CONFERENCE RECAP

SUBJECT: TRACT A4 & A5, BELLEHAYEN RD

DATE: 1-9-84
JOB NO. D01-126-50
RE: Day Surgery Center

REF: DAY SURGERY CENTER (J20-D16)

DRAINAGE PLAN

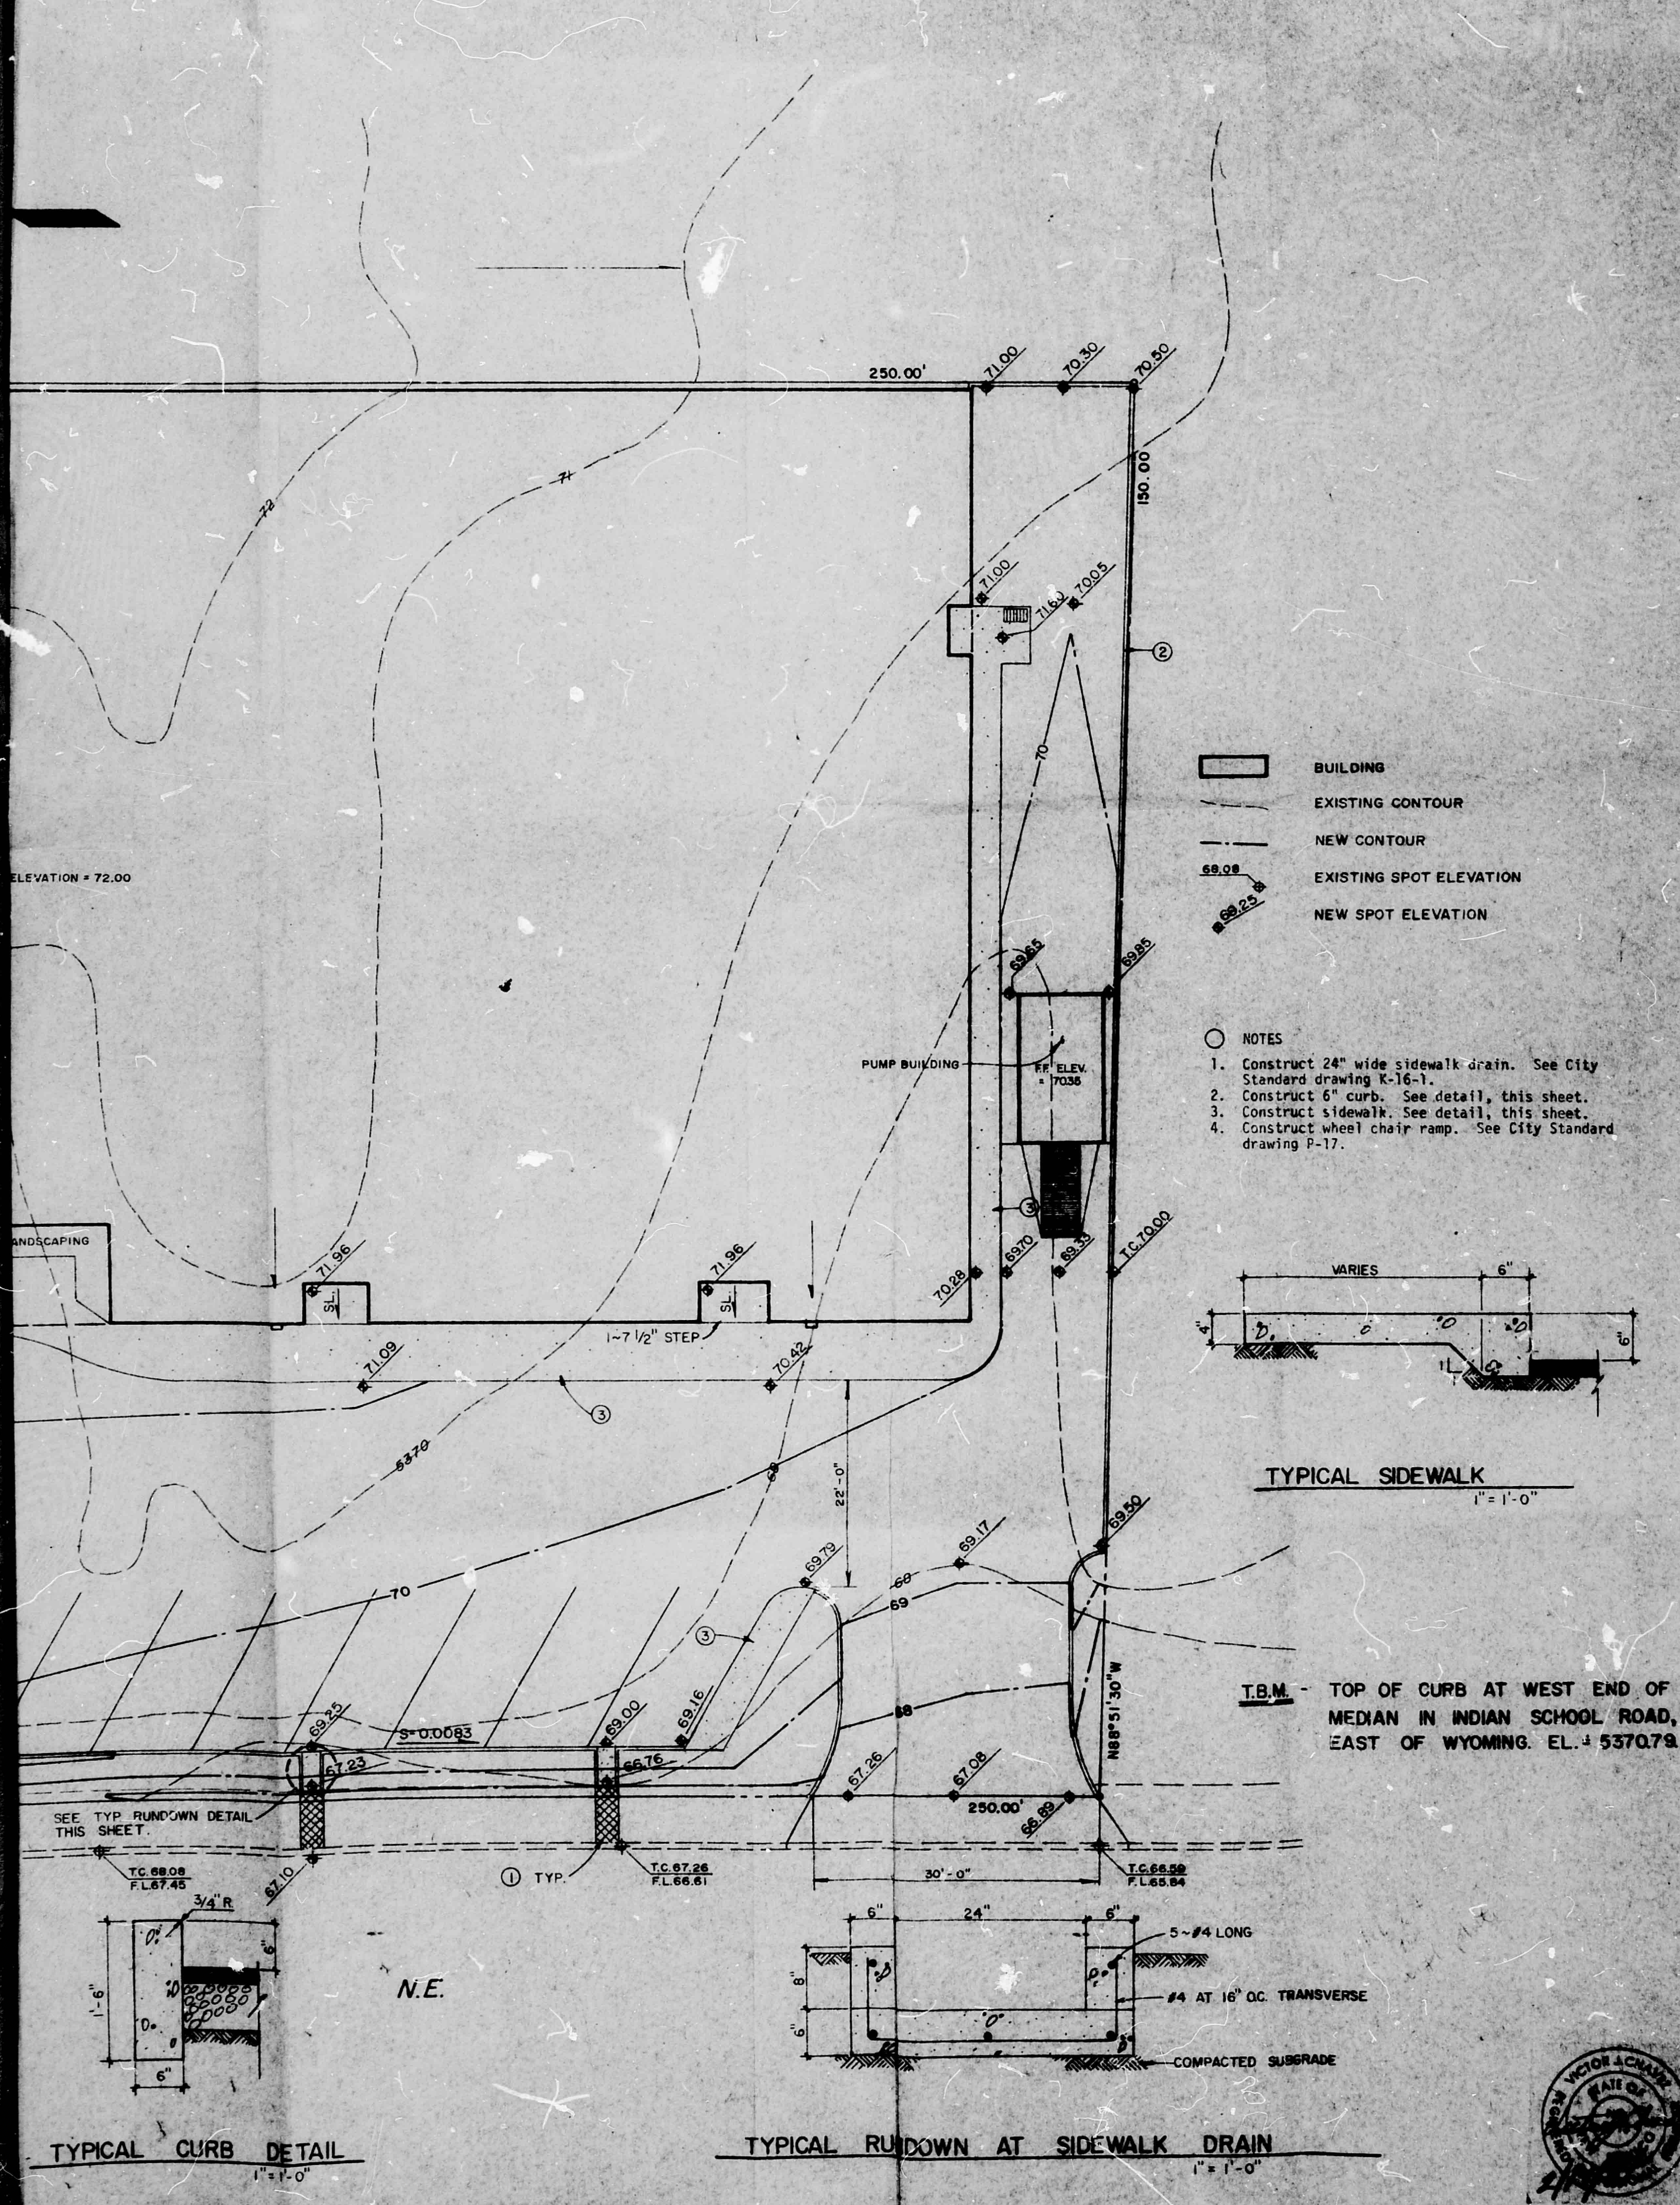
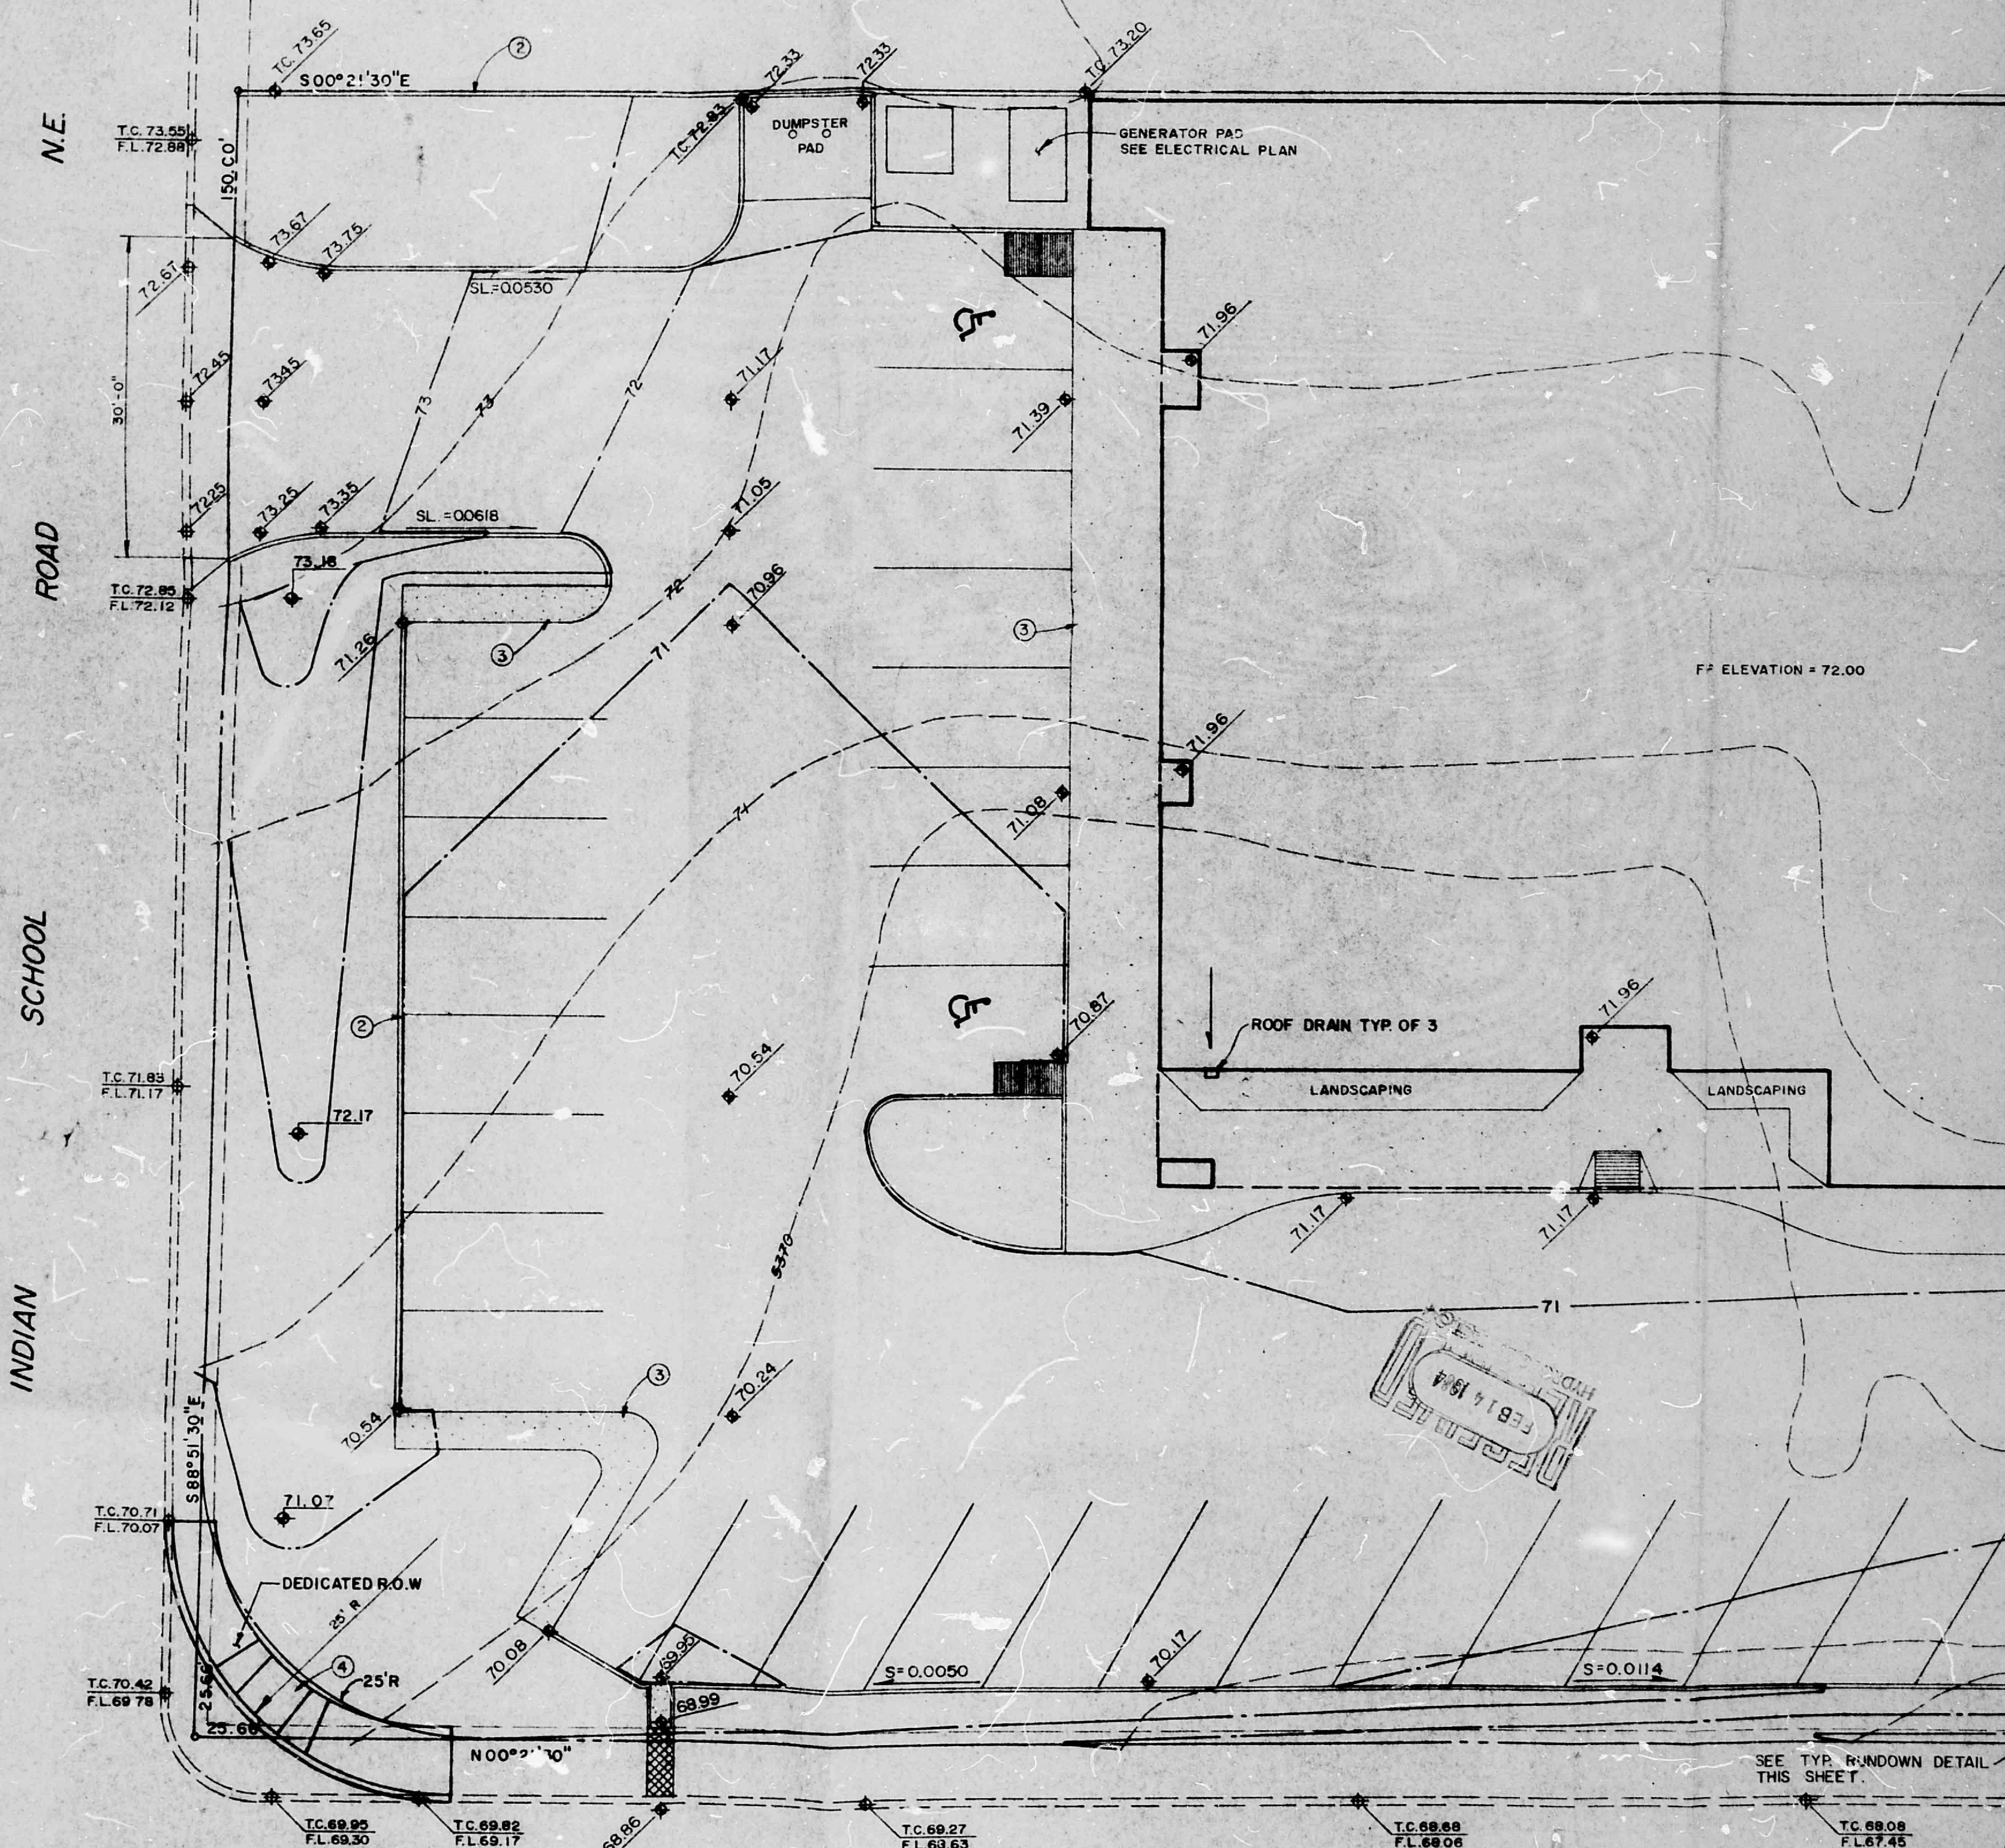
1. Professional stamp with signature and date required.
2. Lot line removal is required unless drainage easement is obtained.
3. Distances along perimeter of said lot.
4. Elevation at property line must be .33 of a foot above the top of the curb, grades along Indian School Road don't reflect these.
5. Location, description and elevation of the:
 - a. Identify the Albuquerque Control Survey vertical datum used.
 - b. Has TBM been marked with concrete cut or other identifying feature.
6. Show limits of curb along west parking area.
7. Show direction and location of all downspouts (if downspout location is situated in area of heavy pedestrian traffic, it may be advisable to locate downspouts under the concrete perimeter walk to exit onto the paved area).

8. "Drainage Facilities Within City R/W" design must be submitted to Bob Kielich's Office for review (construction plan sets will not be signed off without inclusion of said approved document).

1. Professional stamp with signature and date is included on attached plans.
2. Lot line has been removed and a copy of the replat is attached.
3. Distances along perimeter of lot have been added.

4. Elevations have been modified to reflect a minimum of 0.33 of a foot above the top of the curb along the north property line. This has been provided by using an earthen berm. The existing sidewalk will remain and does not presently provide the required heights.

- 5.a. B.M. 7-H20-ACS Brass cap was used as the vertical datum for the job. The cap is located at the northeast intersection of Indian School Road and Wyoming Blvd.. EI= 5371.08.

- 5.b. The T.B.M. has been described on the plans and is located on the west end of a two foot radius curb nose which should be easily identified. It has not been marked to my knowledge. If there is any problem identifying the point, the datum point described above is visible from the site and can be used as a T.B.M..

6. The curb will run along the entire west edge of the parking lot and is shown on the attached plans.
7. All downspouts will be located along the west end of the building and will discharge downstream of the sidewalk.
8. Plans for the "Drainage Facilities Within City R/W" have been submitted to Mr. Kielich's office for review. Copies will be forwarded to you as soon as they are approved.
